Case Officer: Hannah Kersley
Reference: AW/100/22/T
Location: 63 Barrack Lane, Aldwick, PO21 4DE
Proposal: Fell 1no. wild cherry tree (T1)
Reasons given: Causing damage to front lawn. To stop damage to drainage pipeline and inspection chamber.

Overview					Picture 1. T1 showing tight included unions between stems

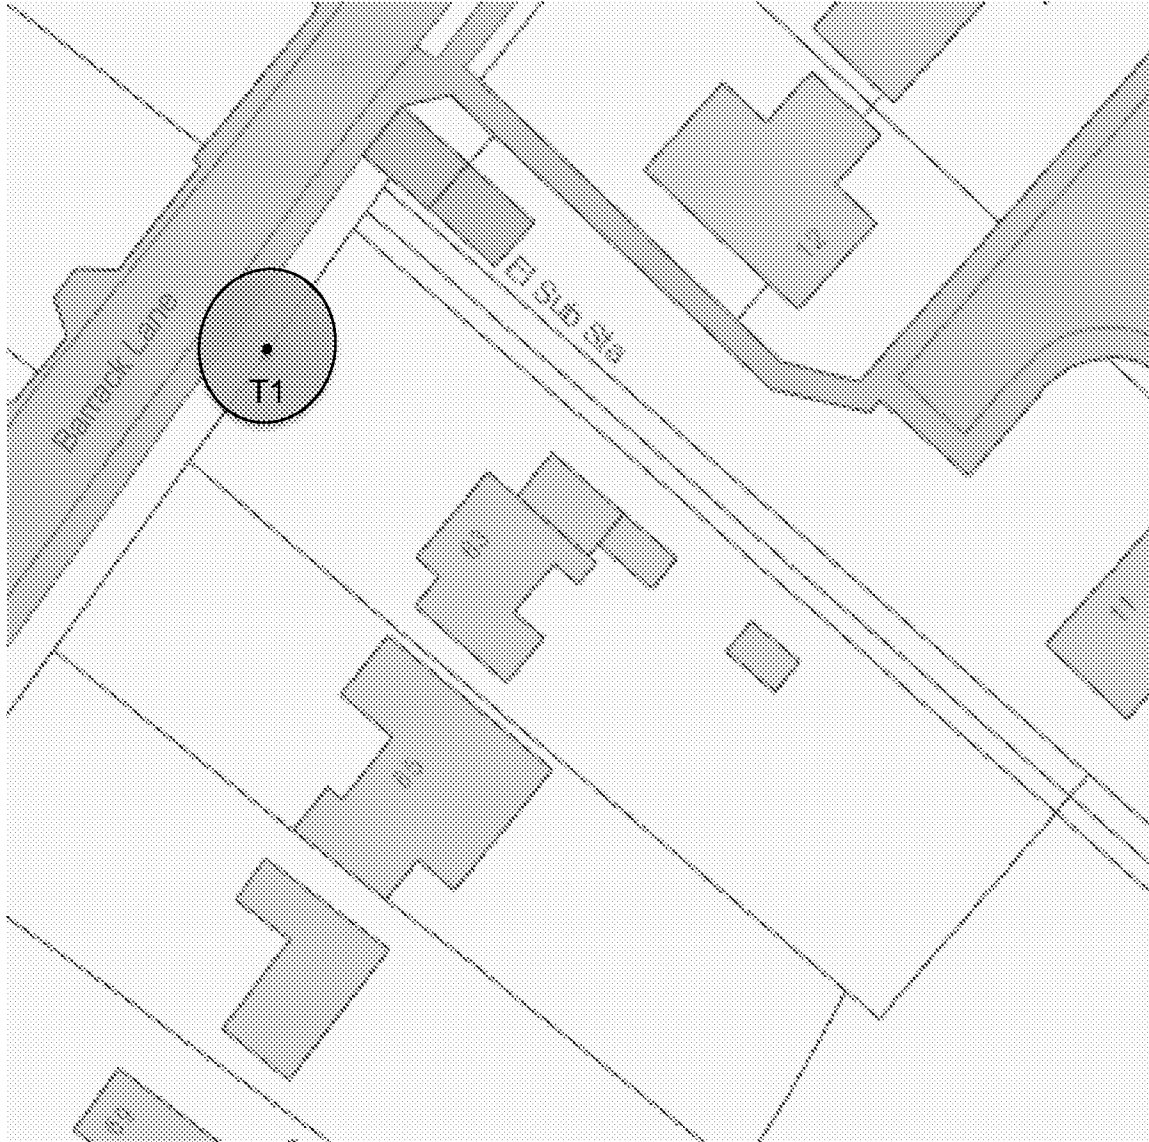
- The work proposed has not been justified on arboricultural grounds. Structural imperfections such as described in the consultant's report are typical of species type at this life-stage and not sufficient in my view to justify a significant intervention.
- No damage to subterranean utility apparatus has been evidenced.
